STATE OF NORTH CAROLINA
DEPARTMENT OF TRANSPORTATION

February 16, 2006

Subject: **APPLICATION REVISION for Individual Section 404 and 401 permits for TIP R-2616** for the proposed widening of US 601 from the South Carolina State Line to north of Marion Lee Road (SR 2105) south of Monroe in Union County; NCDOT Division 10. Federal Project No. STP-NHS-601(4), State Project No. 8.1690303, WBS Element 34485.1.1.

SITE 2 -L- STA 119+34

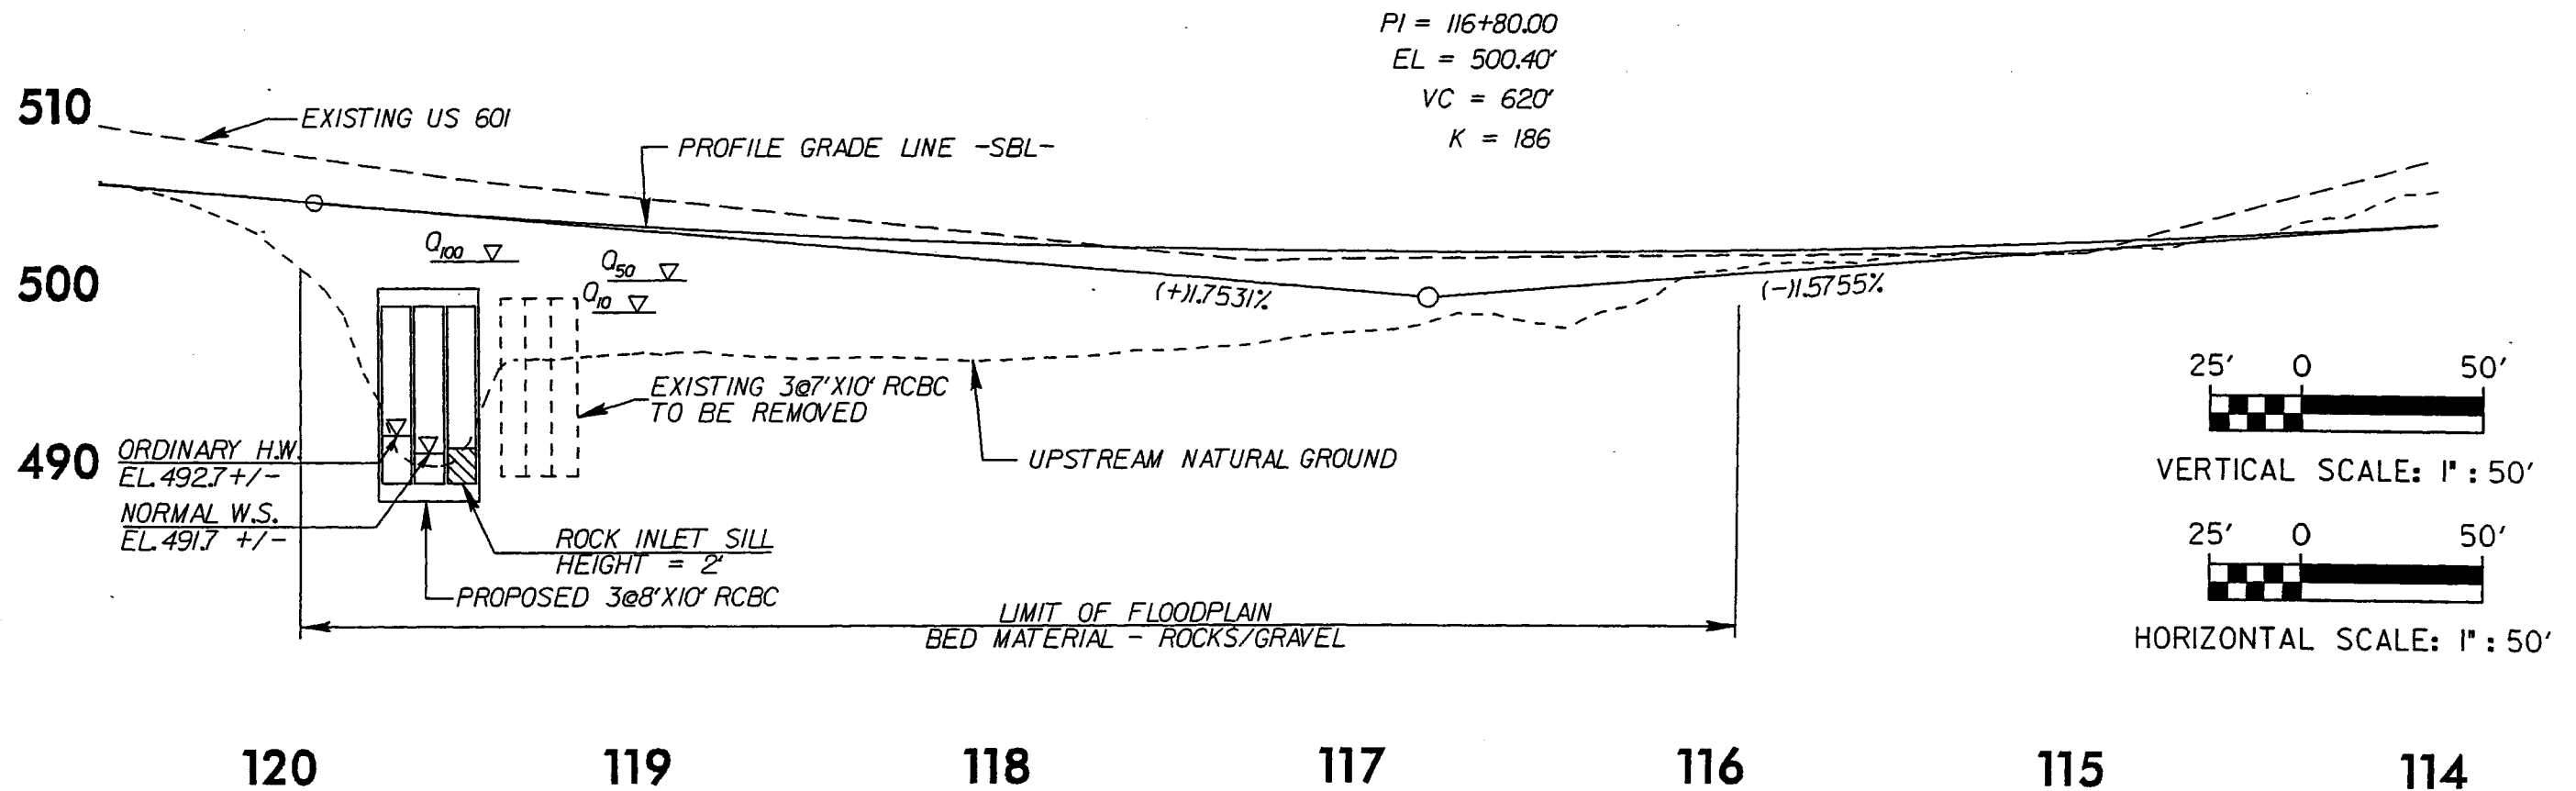
Site 2 (Permit application page 8): The temporary impacts to surface waters for this site have increased by 20 linear feet (from 20' to 40'). This change is necessary for the temporary de-watering activities for the installation of the box culverts.

SITE 3 -L- STA 129+50

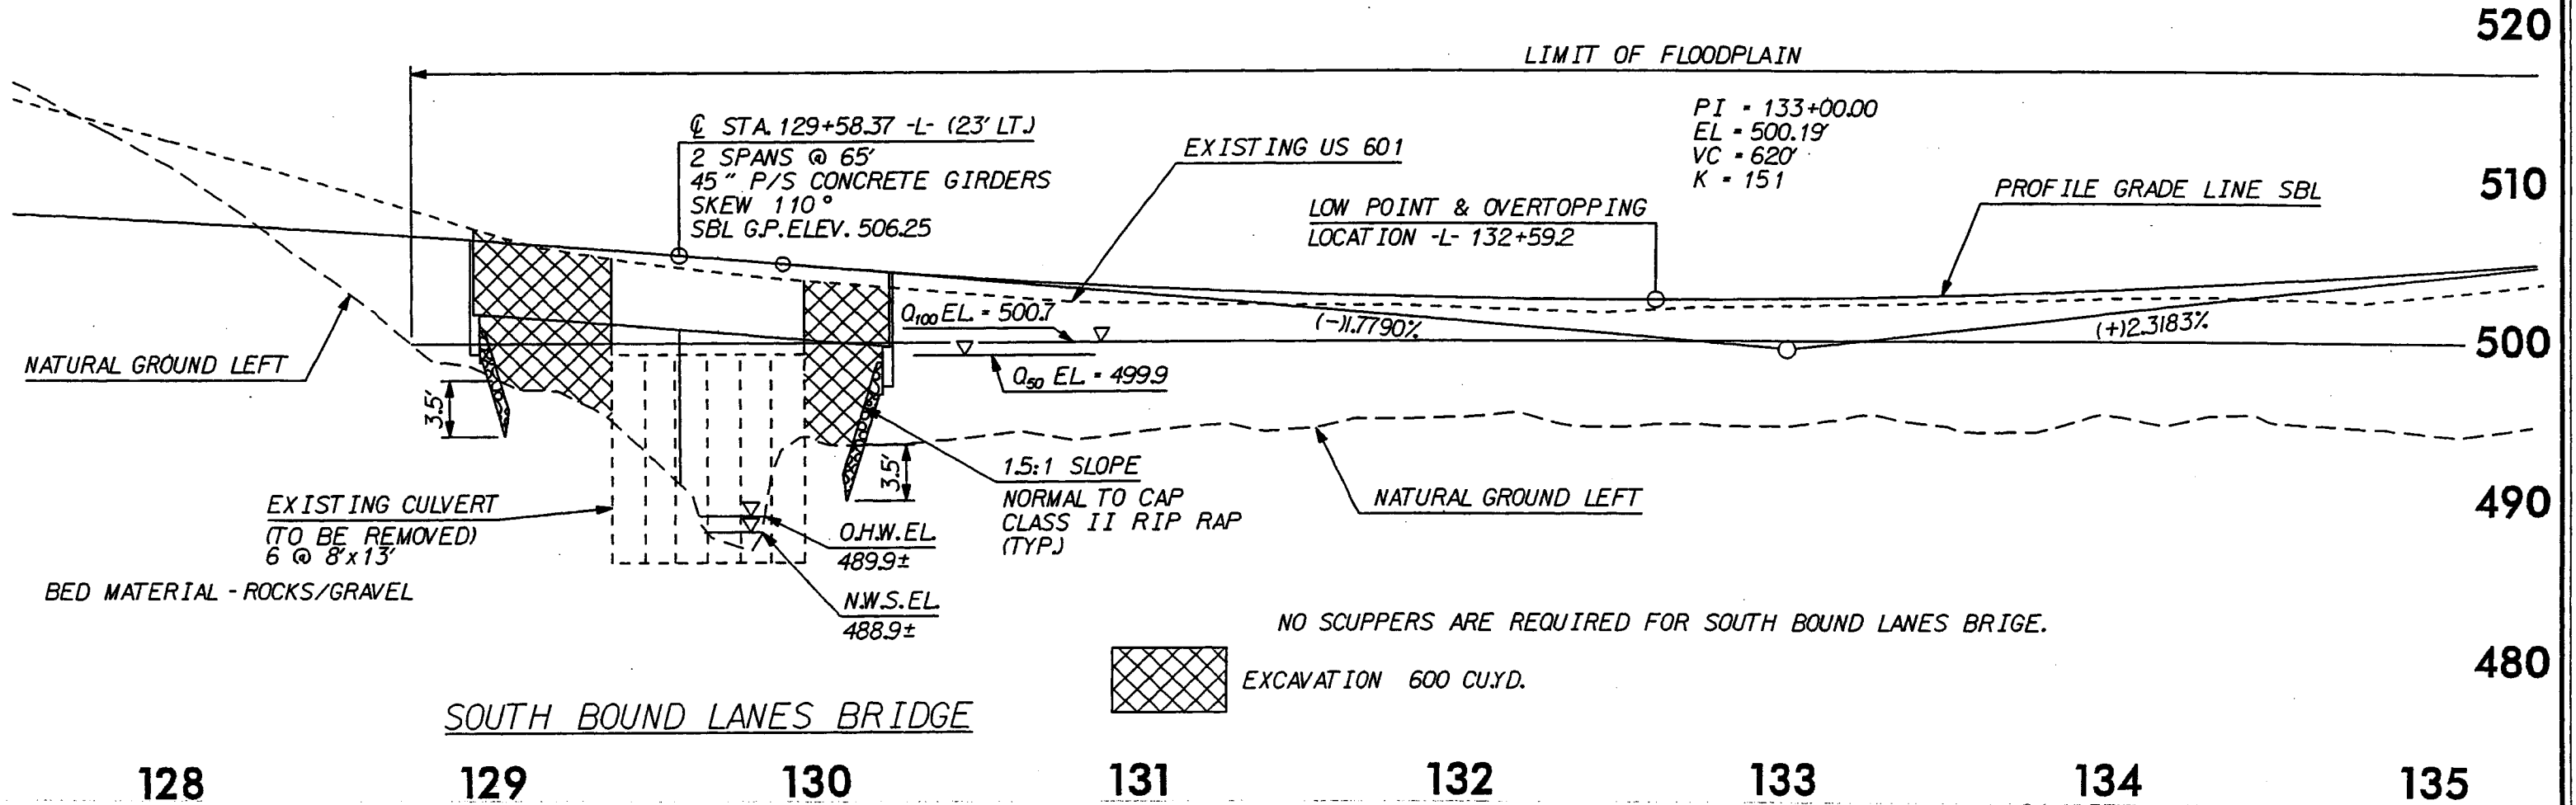
Site 3 (Permit application page 12): The current sextuple barrel box culvert will be removed and replaced with a bridge. We have subtracted 39 linear feet of permanent

stream impact from the total permanent stream impact for the project for using a spanning structure.

SITE 5 -L- STA. 180+00 (RT.)
 SITE 6 -L- STA. 180+00 (LT.)
 SITE 7 -L- STA. 183+00 (LT.)

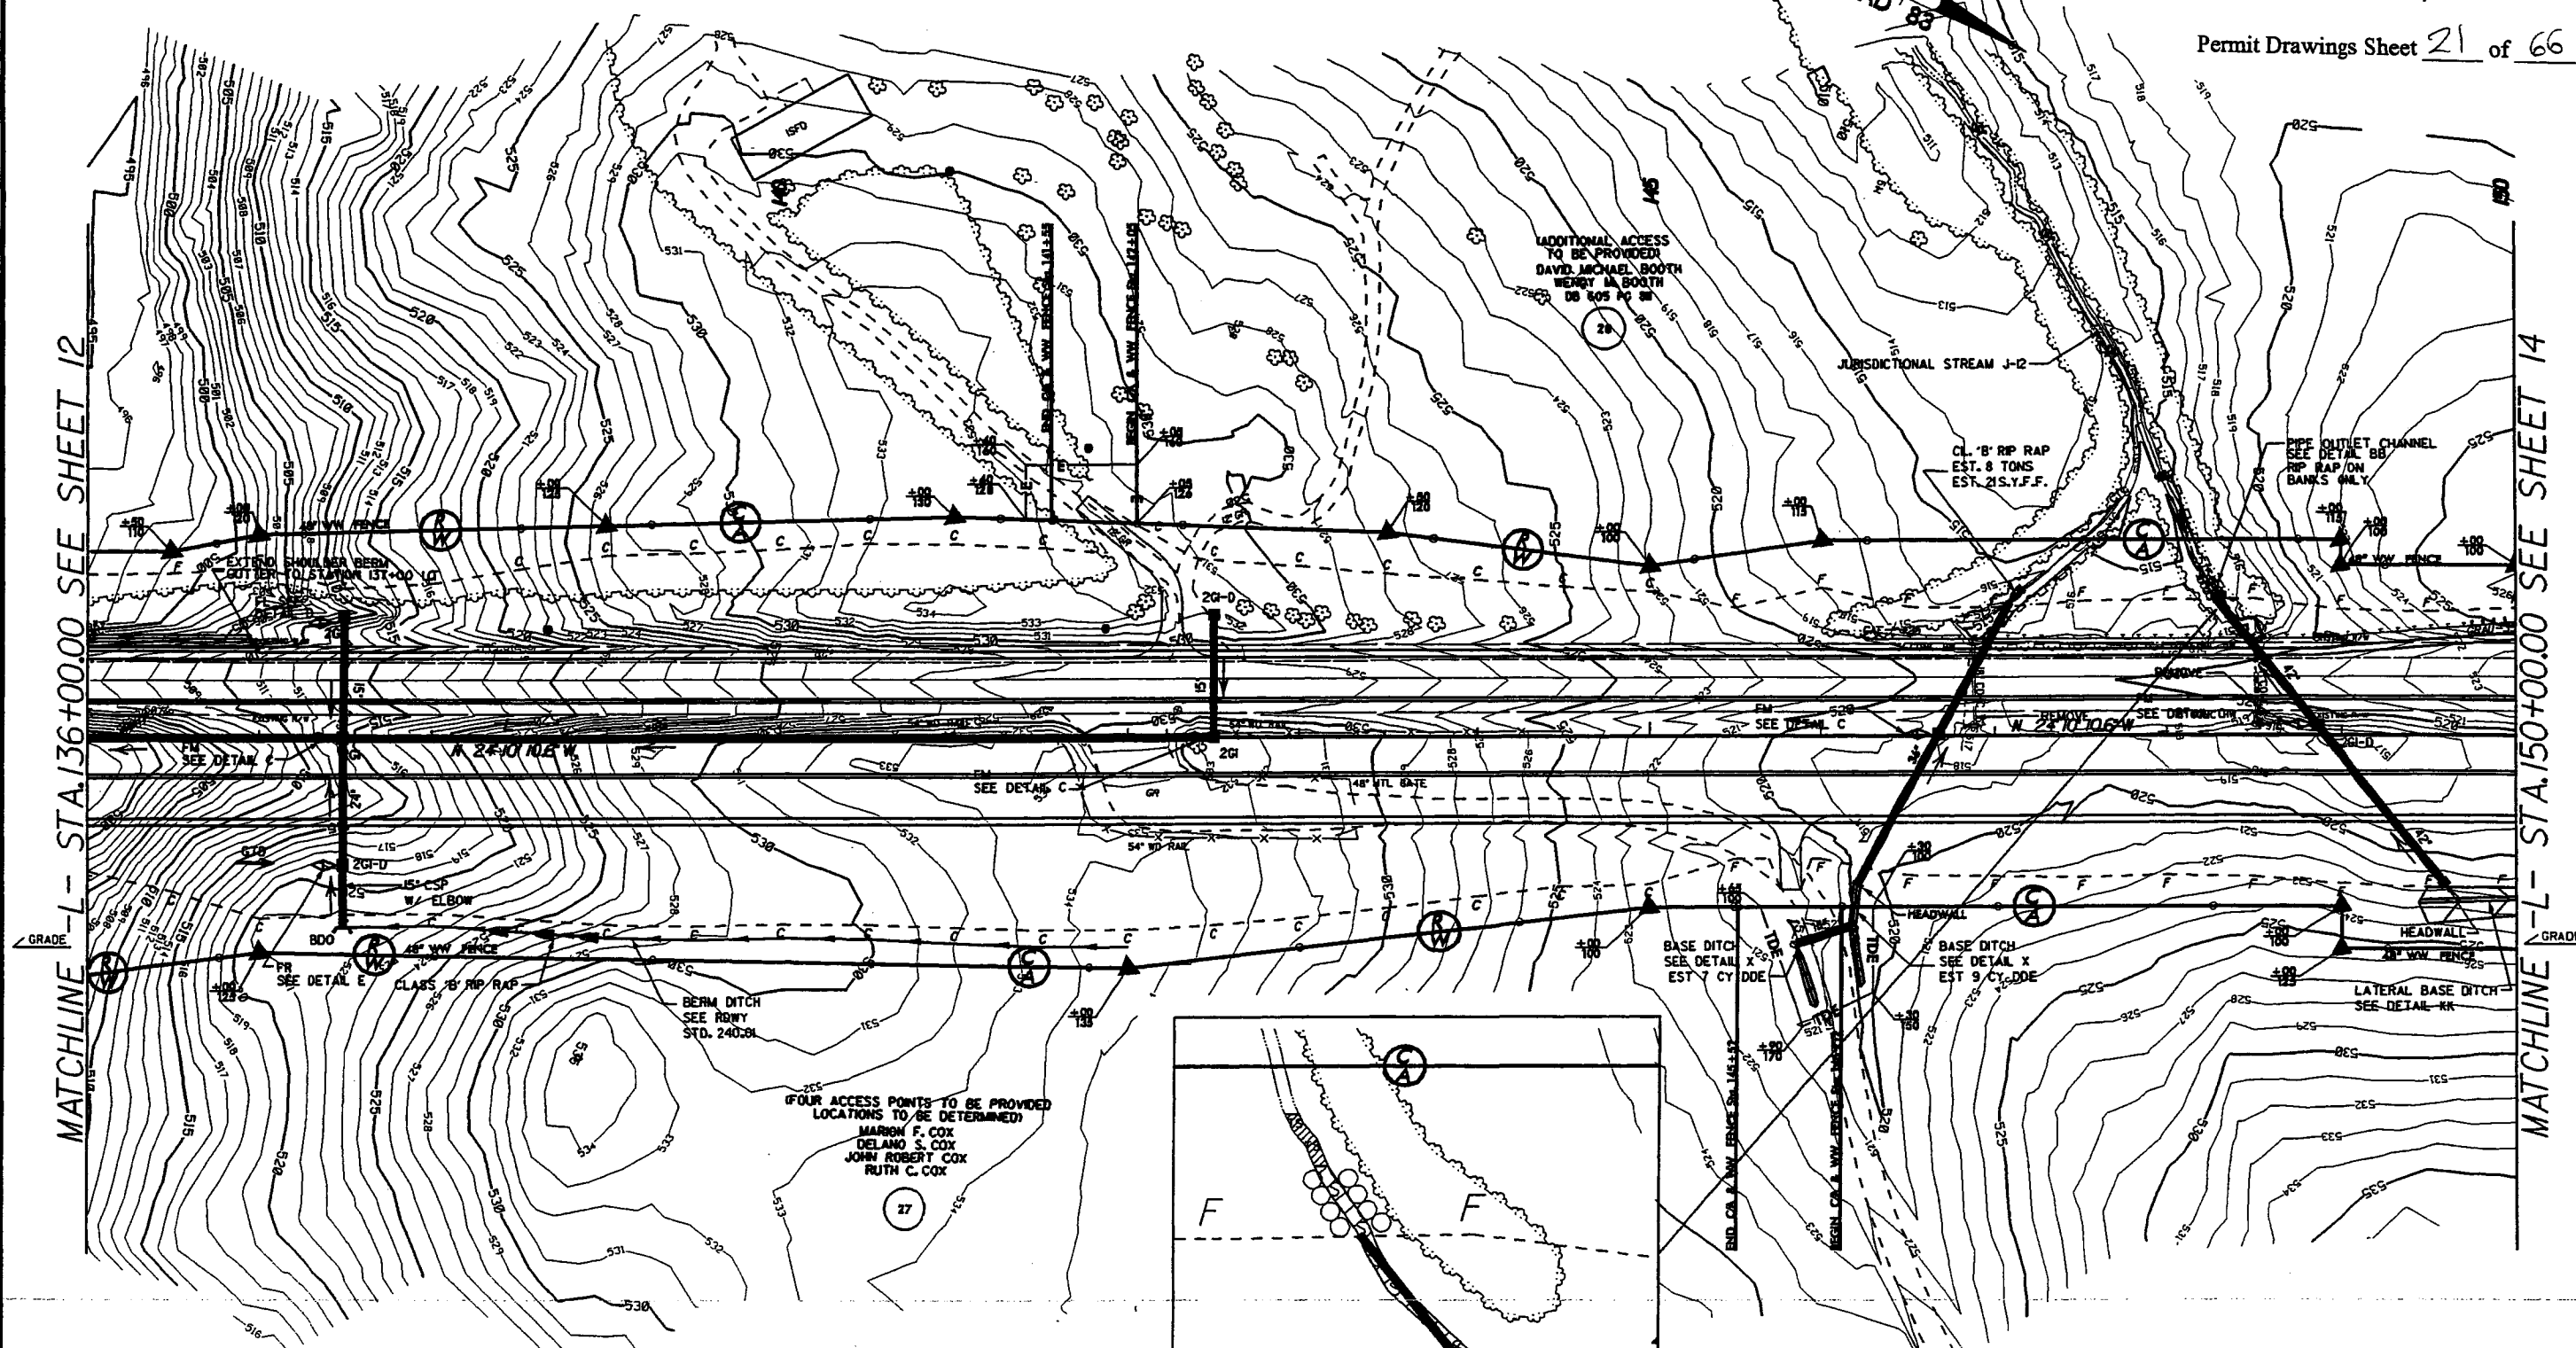
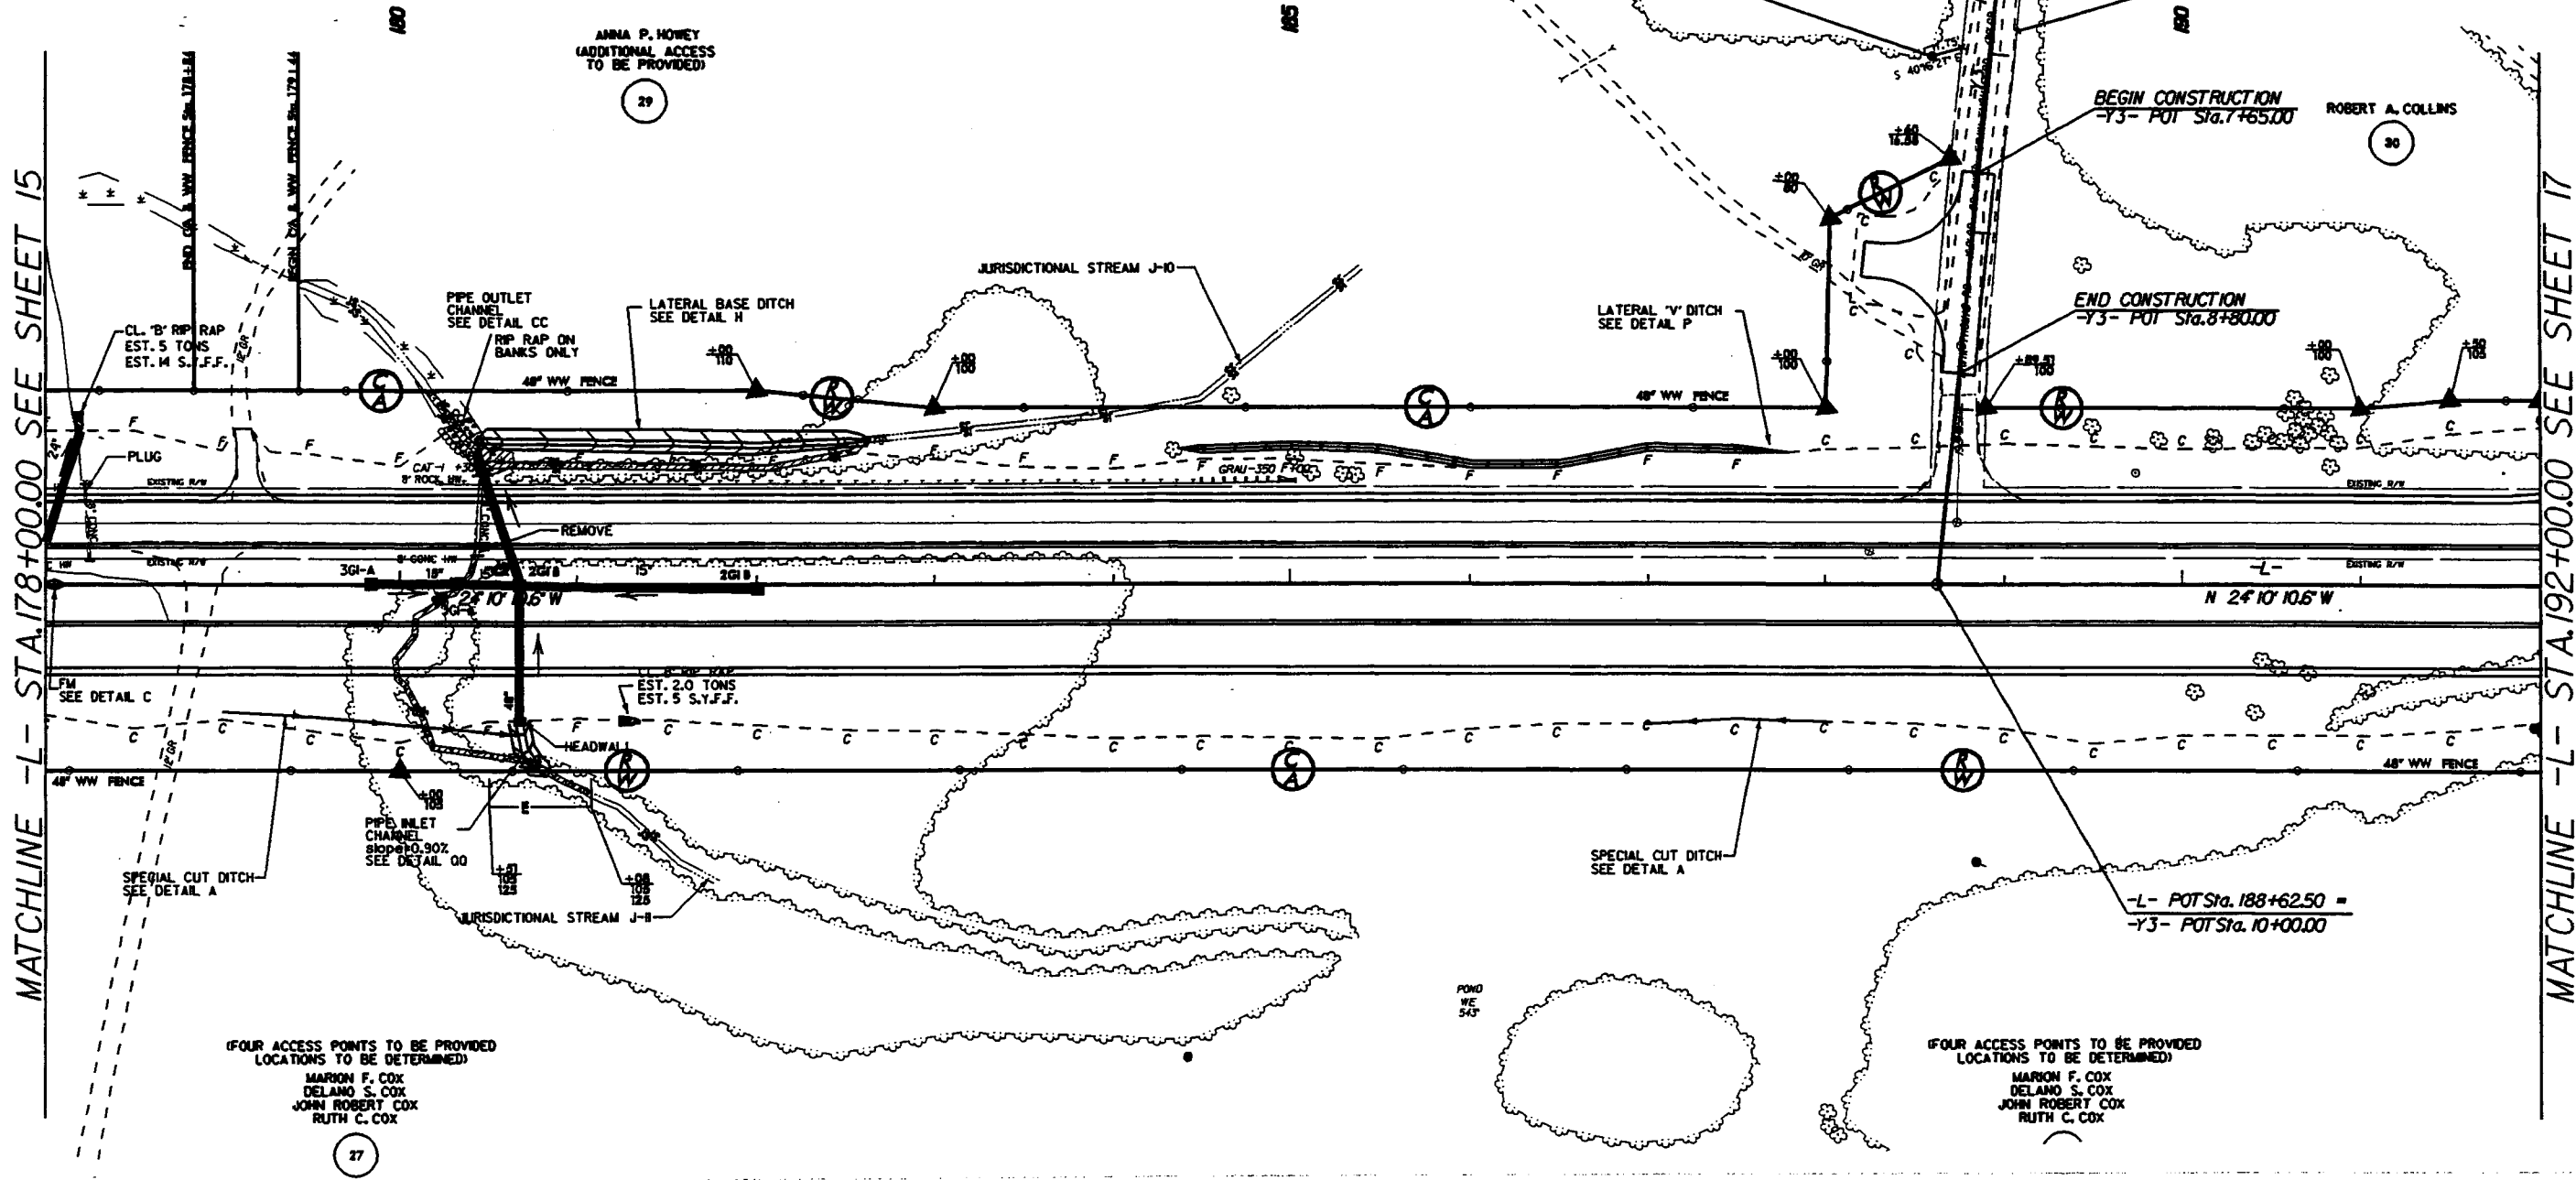
Sites 5 & 6 (Permit application page 18): On the previous impact summary table, the impacts for Sites 5 & 6 were separated into corresponding Left and Right sides of the road, and adjacent wetland impacts were shown with site 6. As the same stream is impacted on the Left and Right sides, the stream impacts have been combined into Site 5, and the wetland impacts are shown solely with Site 6.

The permanent impacts to wetlands have decreased by 0.0011 acre (from 0.015 to 0.004).

The temporary stream impacts have increased by 27 feet (from 11' to 38') due to the temporary de-watering activities for the installation of the box culvert.

Site 7 (Permit application page 18): The permanent stream impacts have increased by 23 feet (from 192' to 215') due to a calculation error.
